Address: 18 Woodhead Road Holmfirth HD9 6PP

Application number: 2023/90444	
What is the application for?:	Erection of detached dwelling
Address of the site or building:	Land adj, Fern Bank, Far End Lane, Honley, Holmfirth, HD9 6NS
Postcode:	HD9 6RP

Type of comment: An objection	
Do you wish your comments to be published on the website anonymously?	No

North Elevation - 1:100

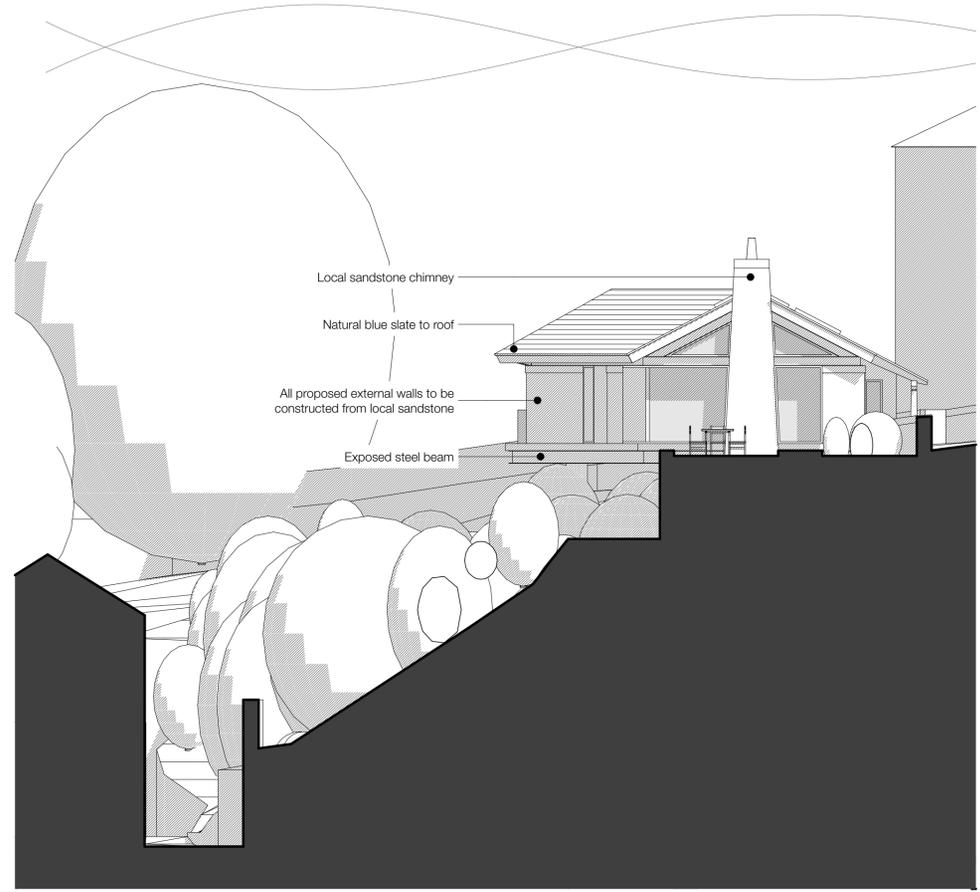
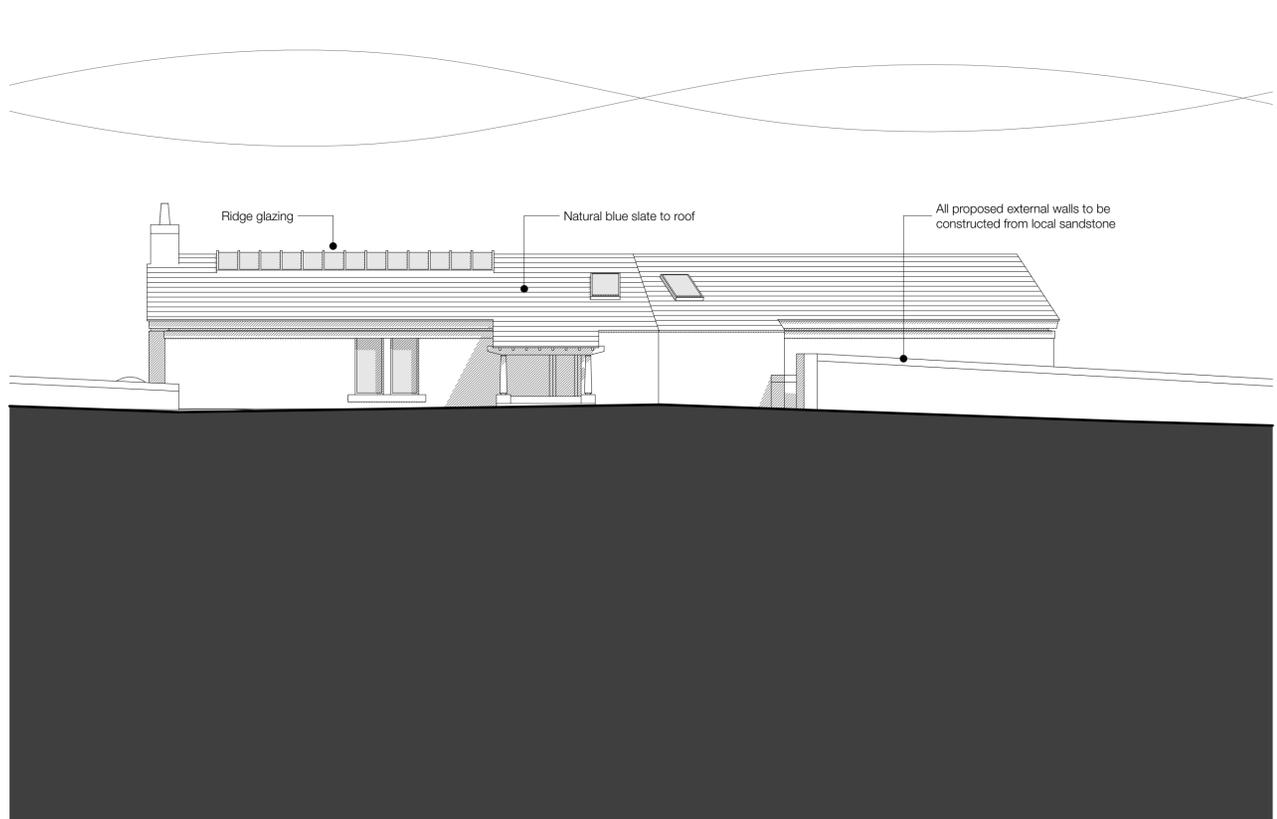
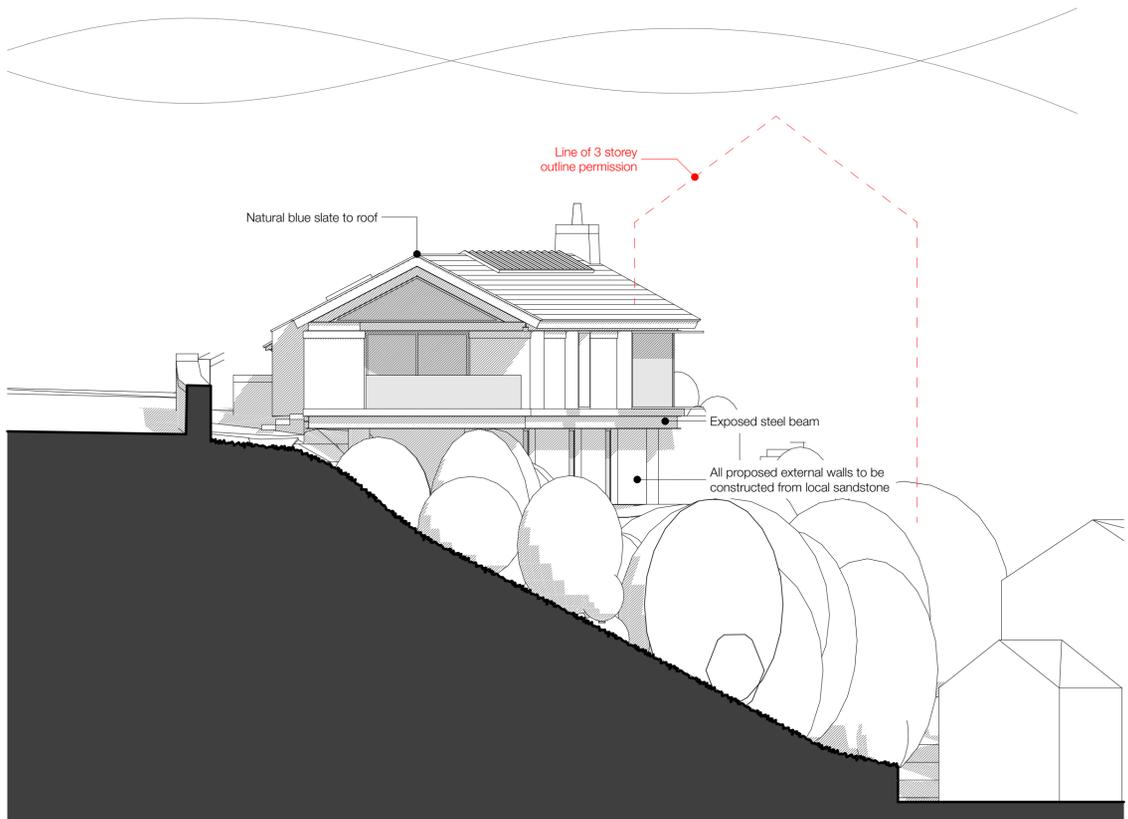
The omission of no18 from the Northern Elevation on the submitted plans is not surprising. Its inclusion would clearly demonstrate the dominance and overbearing nature of the proposed dwelling sitting above no 18 like its mothership!

It would sit wholly above no18's roofline, extending beyond the single storey elevation and above the only garden / private amenity space which is at the side of no18
